Bruce Hunter
905/50 Murray Street
Pyrmont, NSW 2009
17 January 2017

**Objection to the proposed redevelopment (SSD 7874) of Harbourside Shopping
Centre with Residential Tower**

Bruce Hunter - SSD 7874 Objection - Page 2

3pm

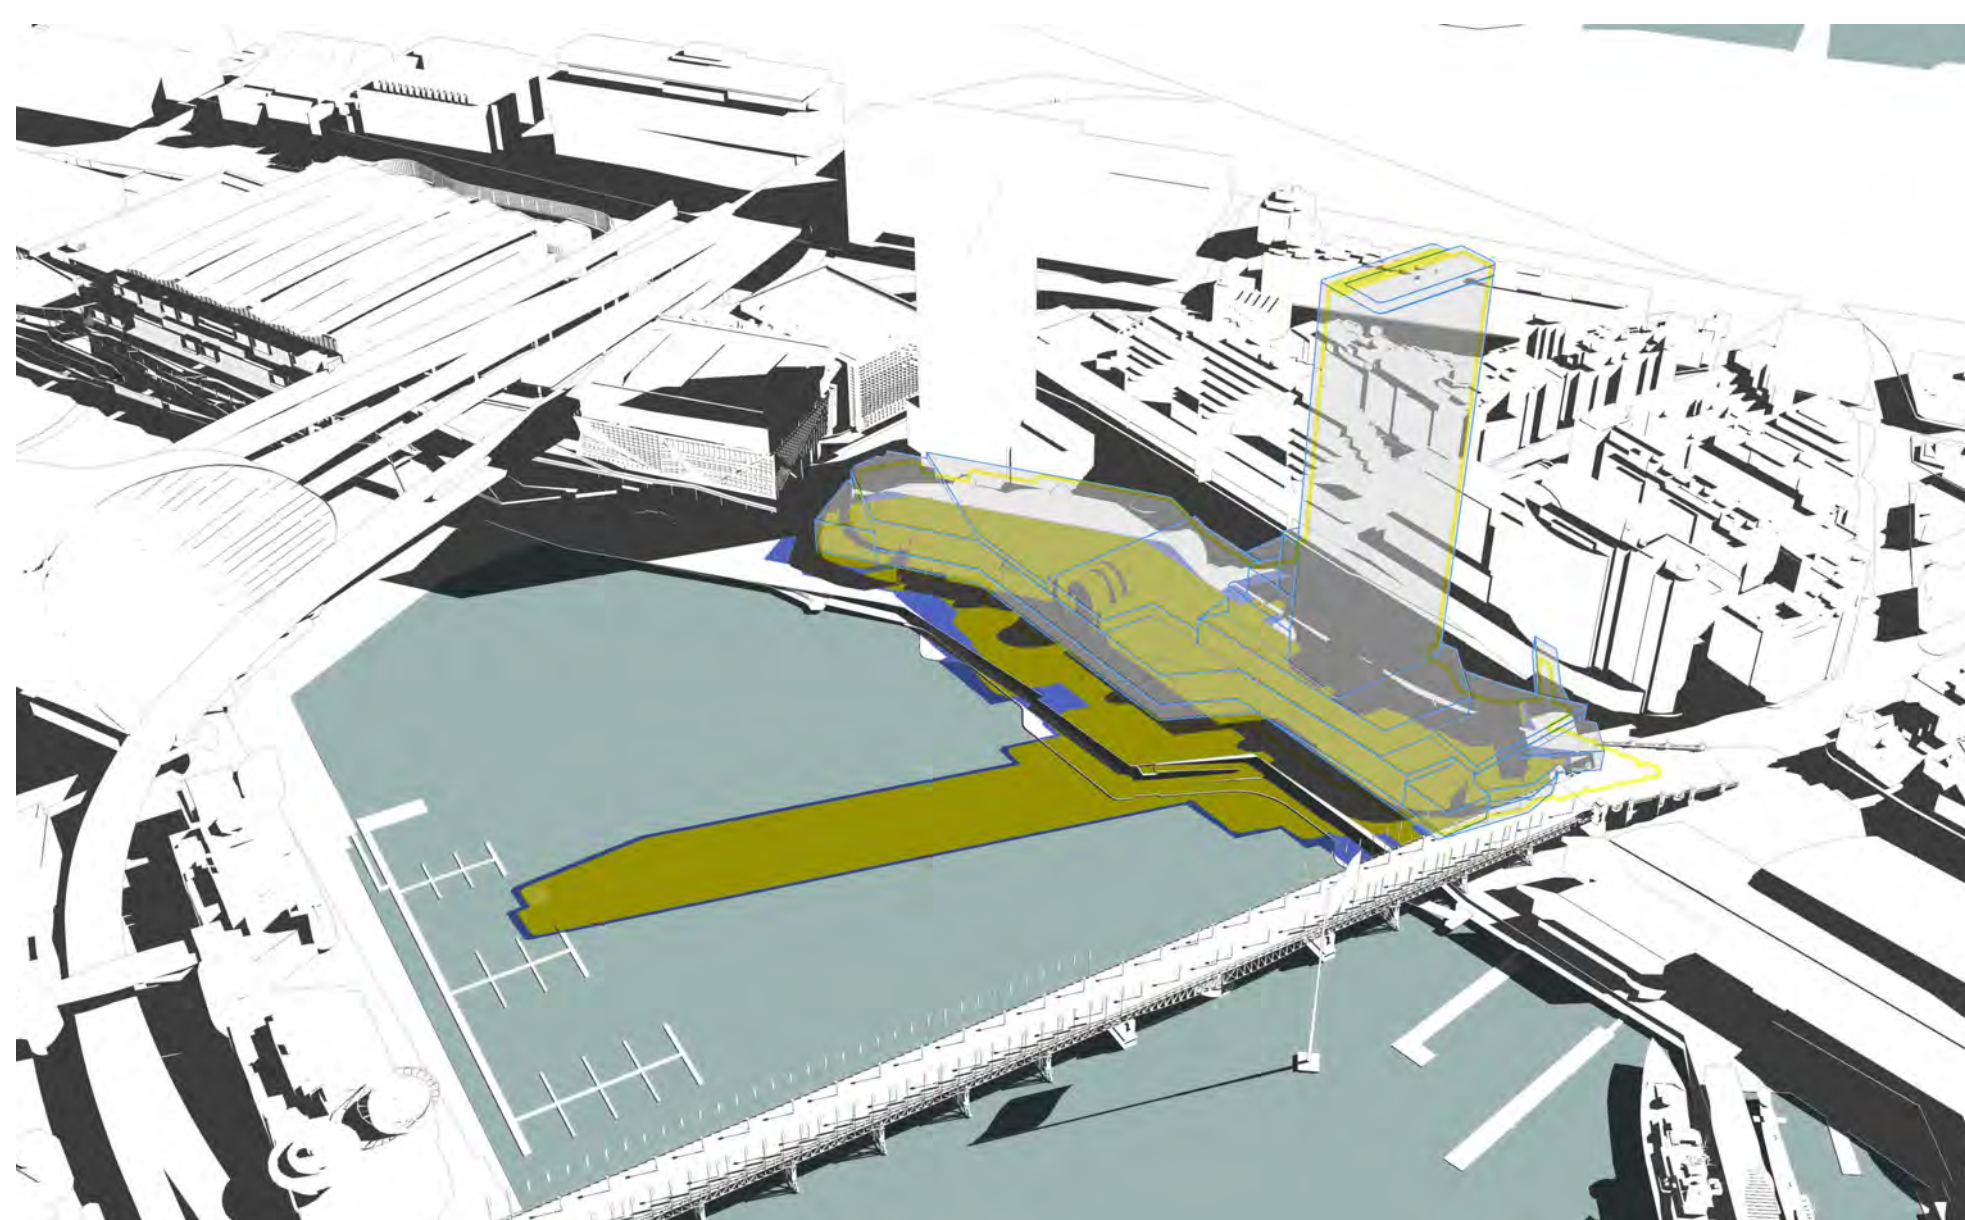
2. There is no justification for the tower included, with the shadow diagrams showing significant shadow impact on Darling Harbour and the residential areas on the western side towards Pyrmont.
